The British Horse Society

Planning Inspectorate

21 Nov. 24

Oaklands Solar Farm proposal

Drawing Title
EN010122/APP/2.4 – Streets, access and Public Rights of Way Plan Sheet 1

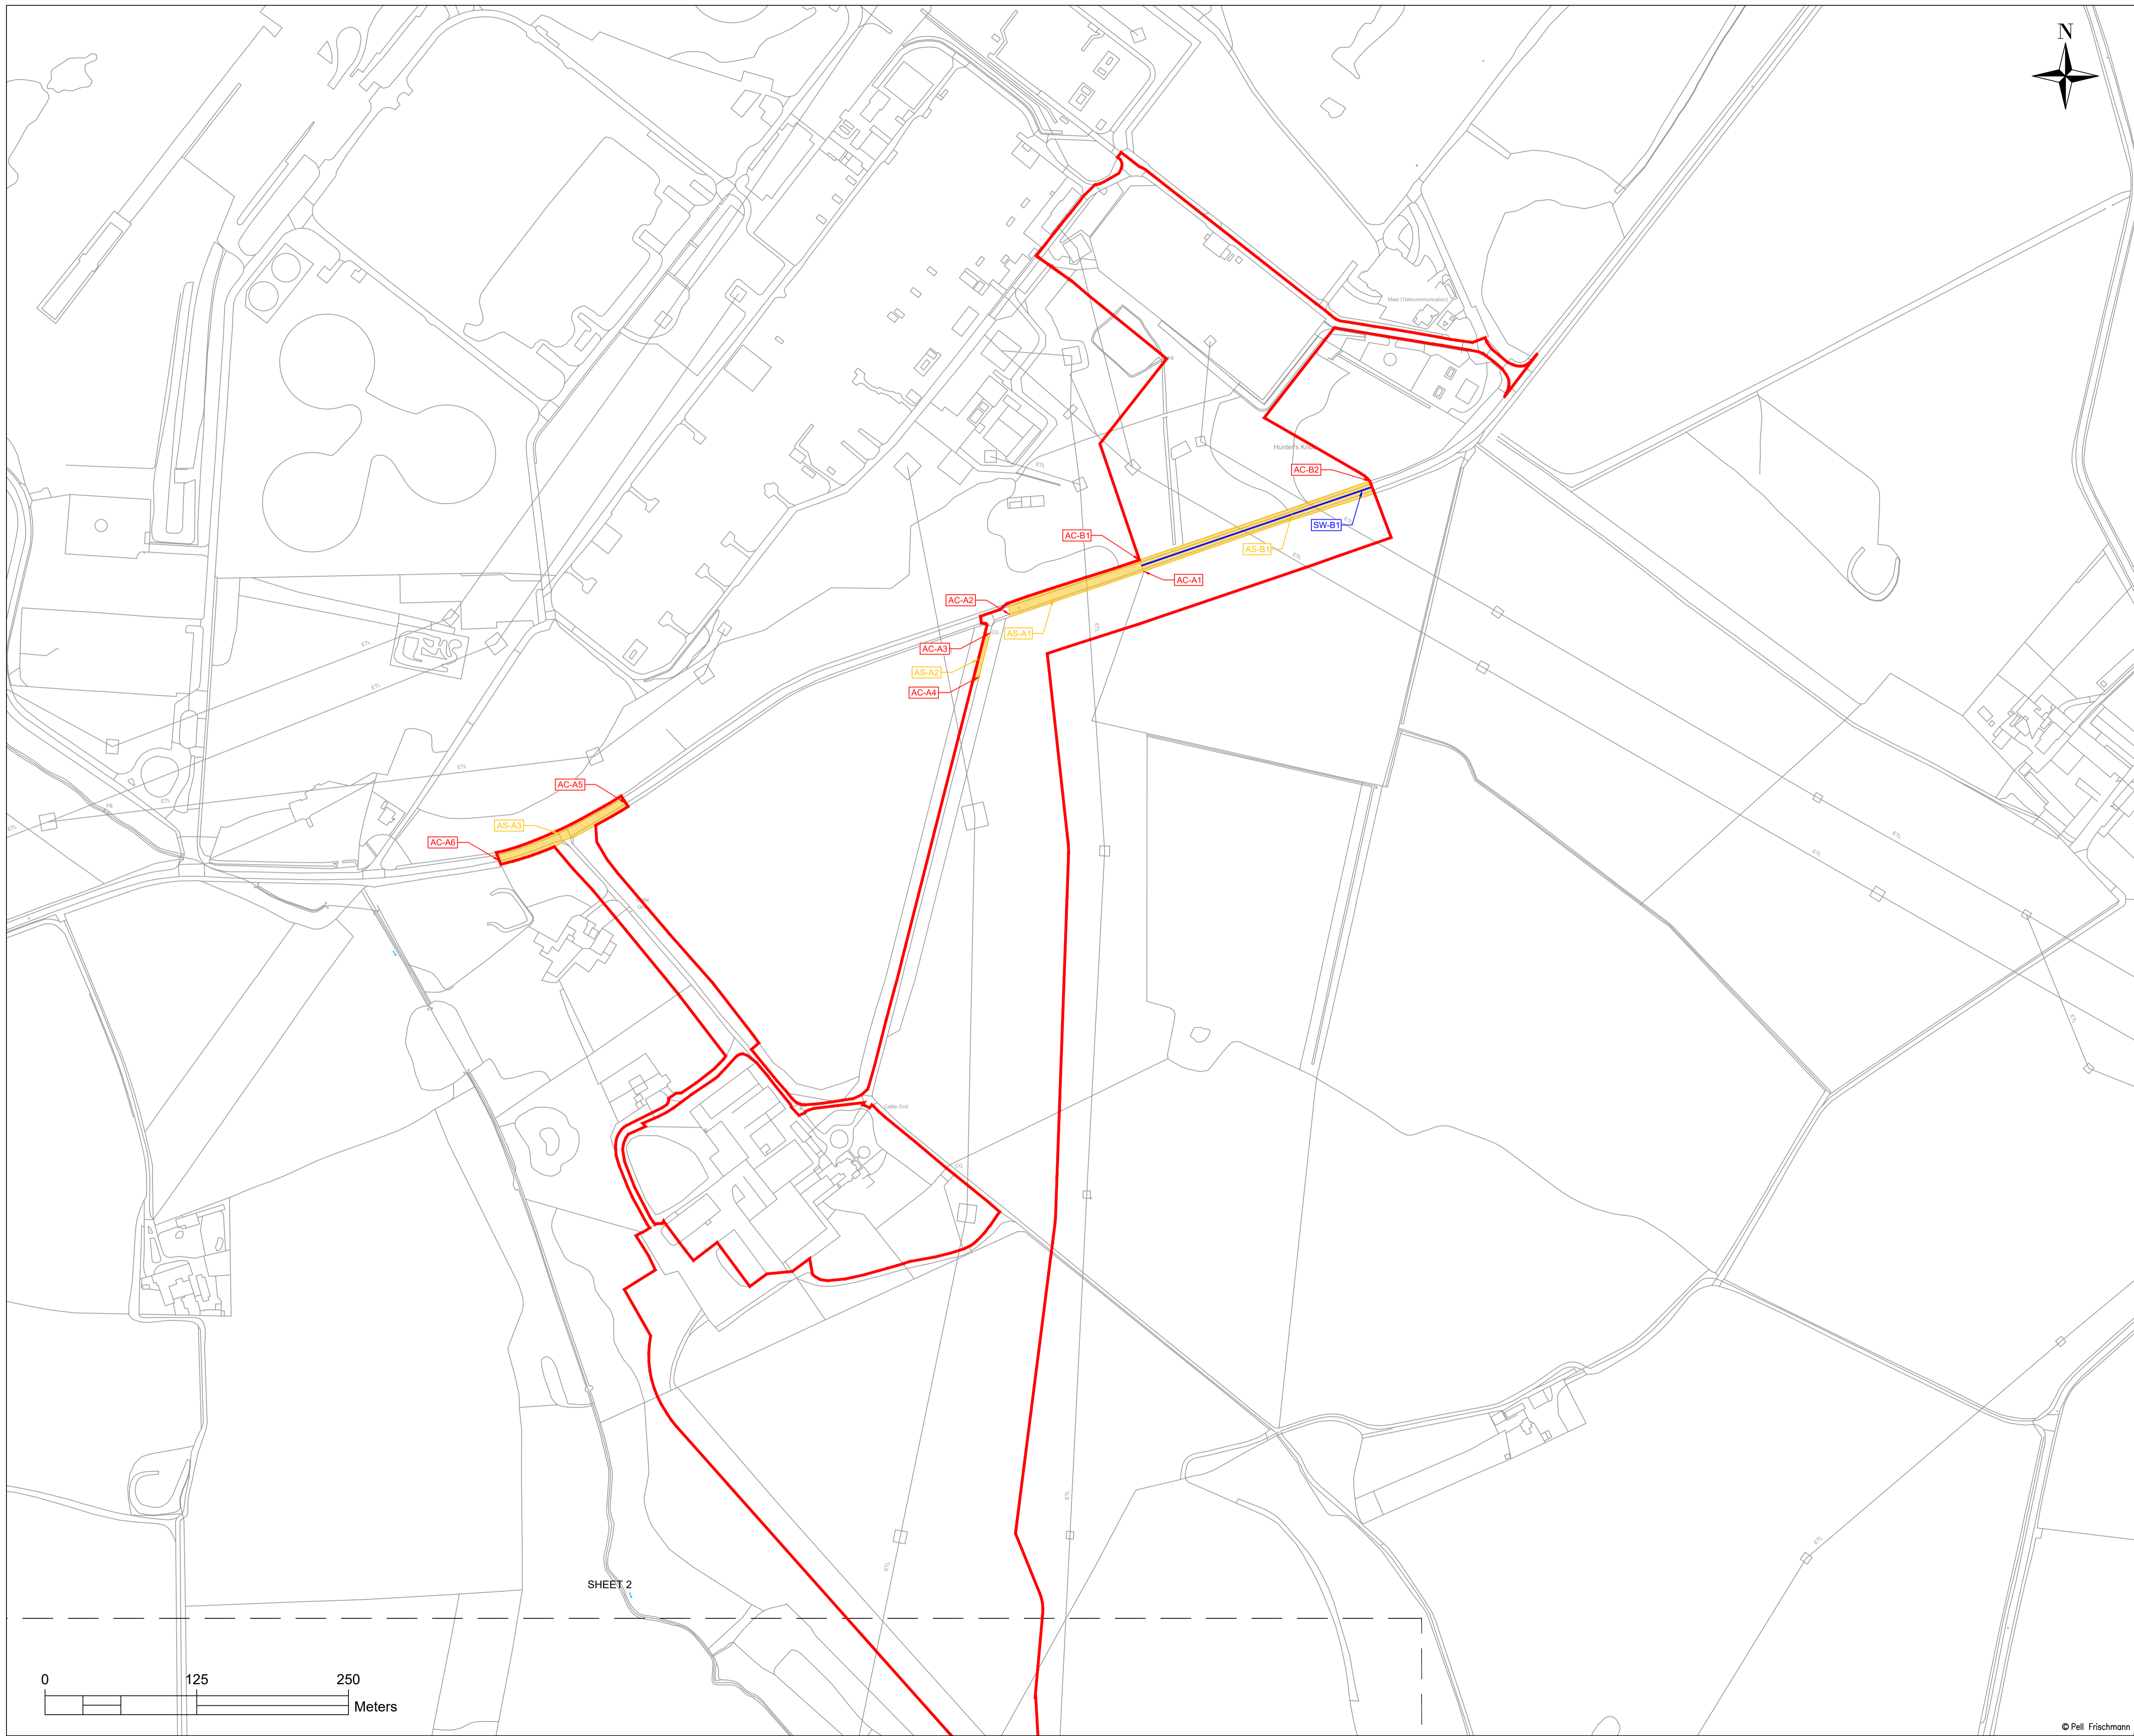
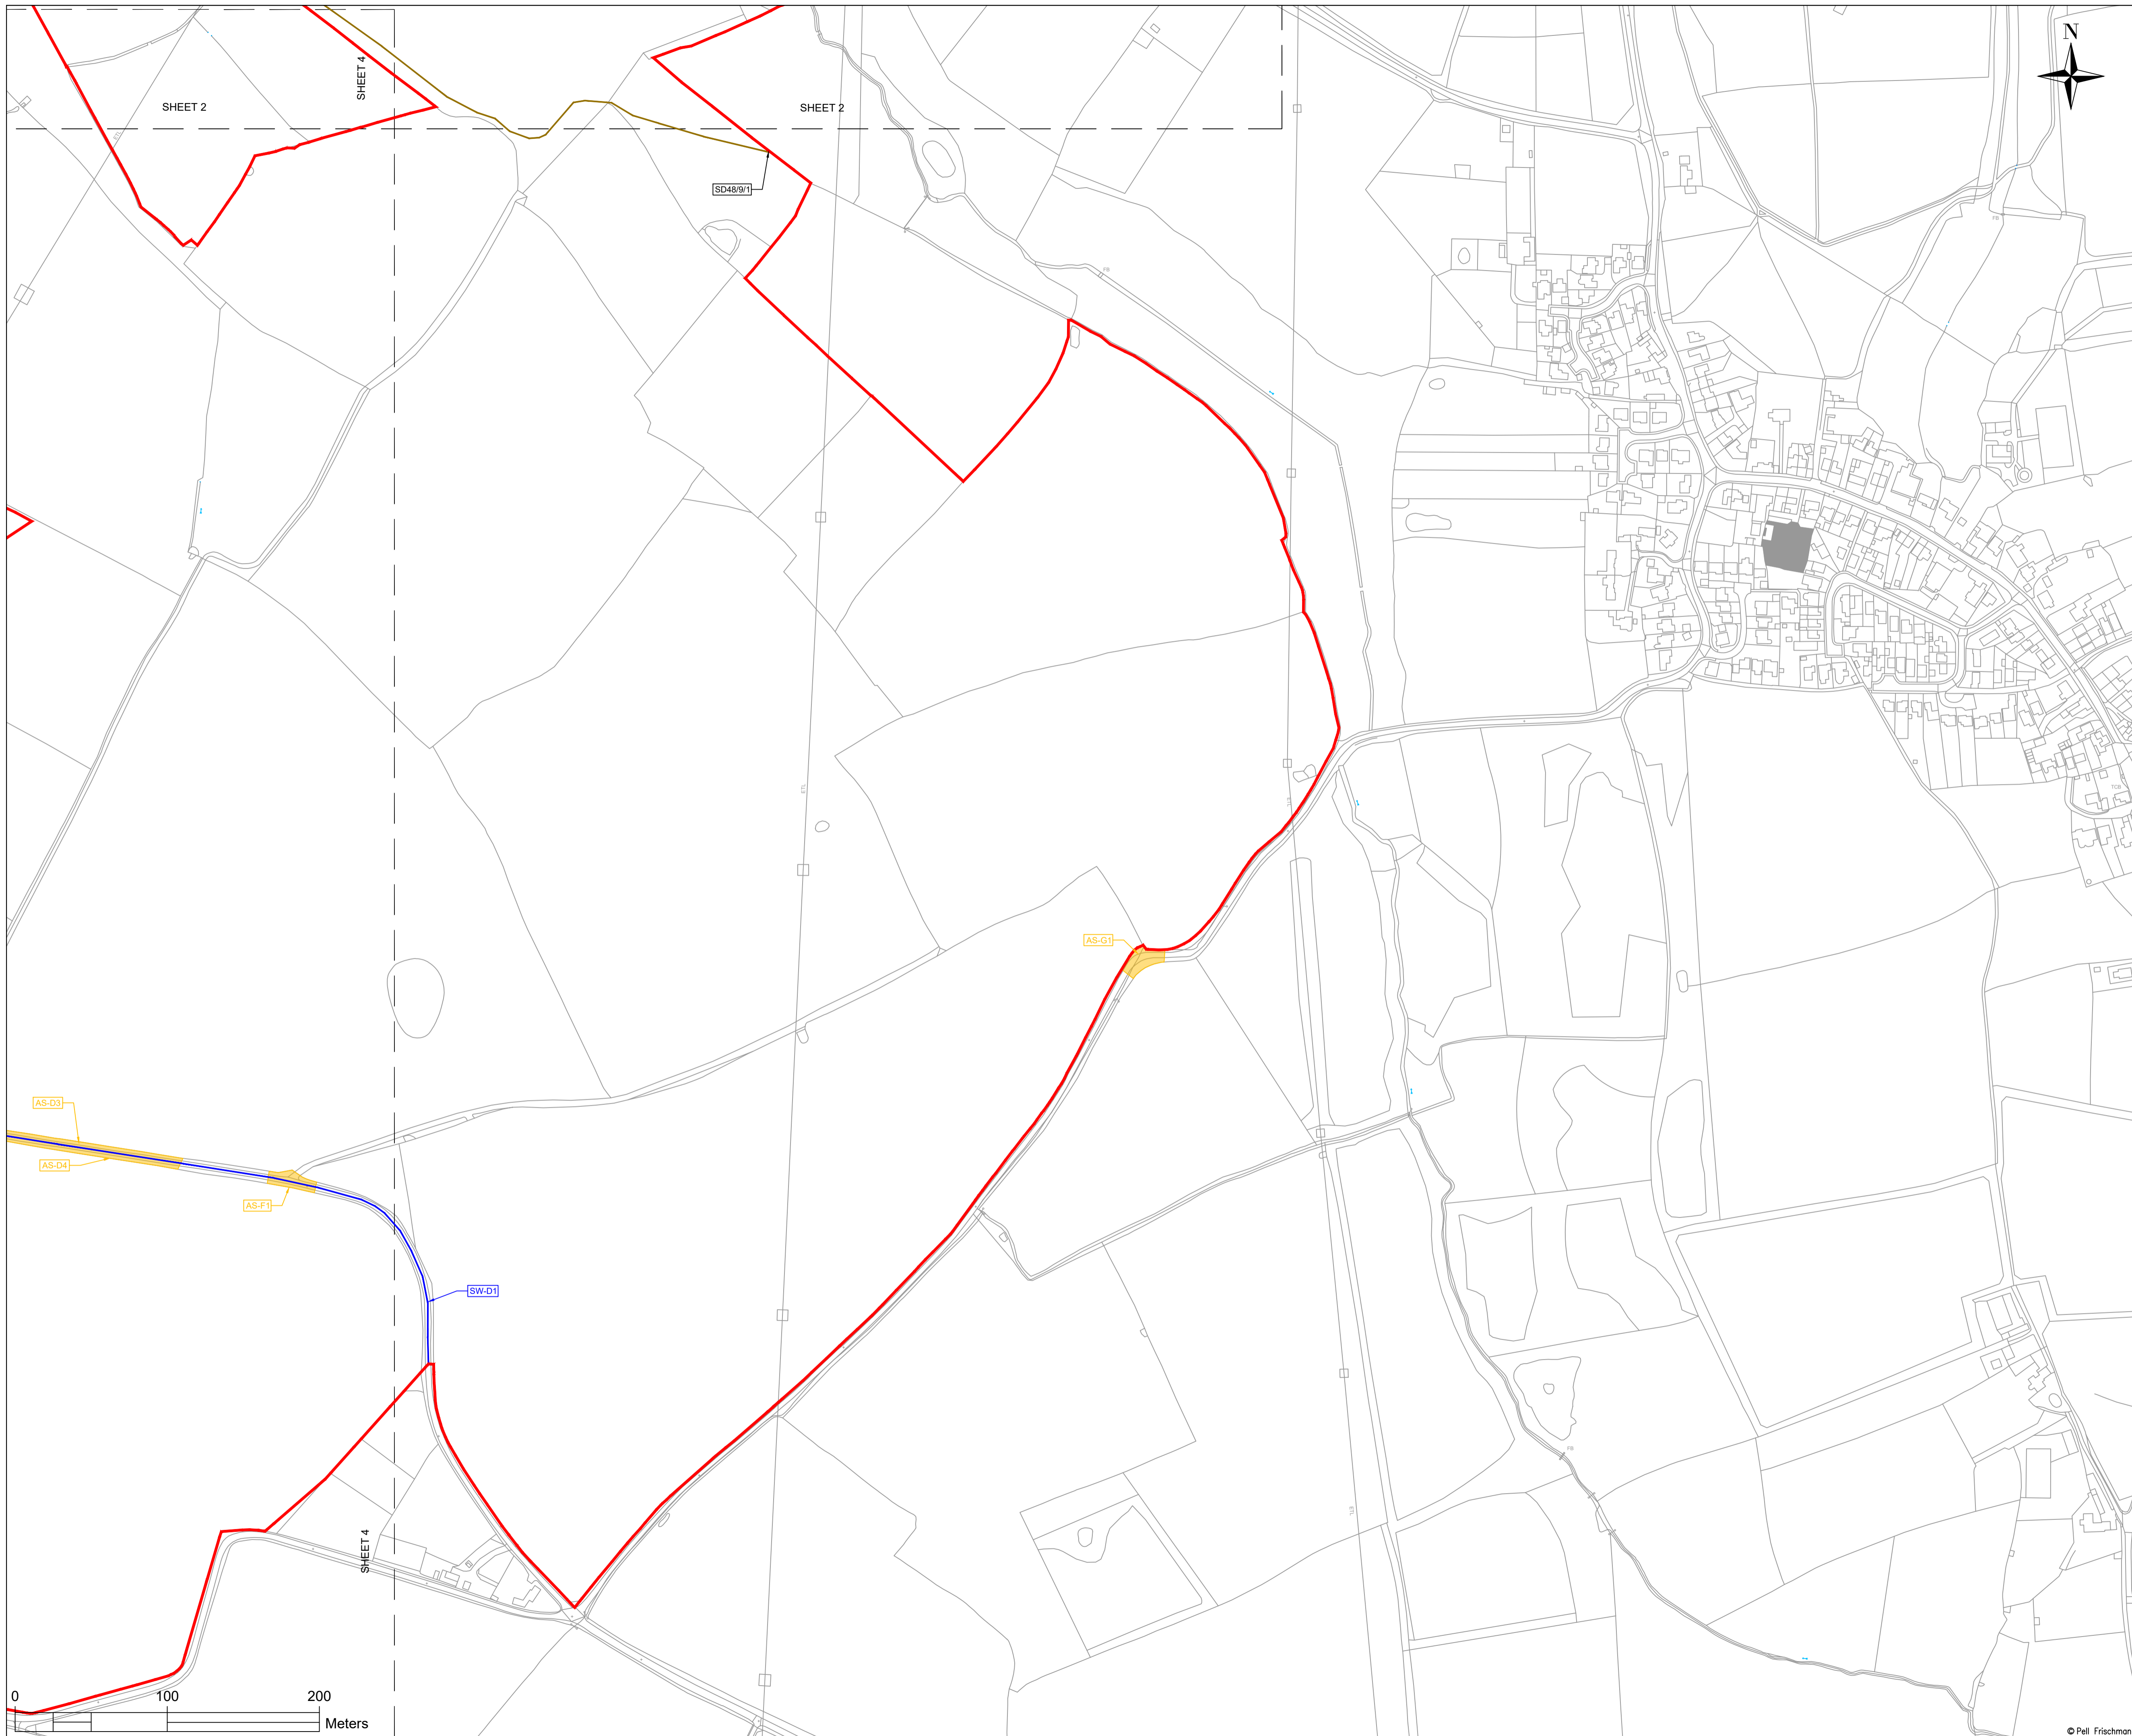
- It was discussed with the Project Lead in 2022, that equestrian access to the proposed permissive routes and permissive bridleways using existing footpaths (Walton Upon Trent FP9, Drakelow FP 5) for the life of the project would contribute to the community and provide off-road access for all vulnerable road users. However, the feedback from consultation does not appear to include any other vulnerable road users other than pedestrians. The dimensions proposed to buffer permissive and public rights of way would provide ample space for shared use.
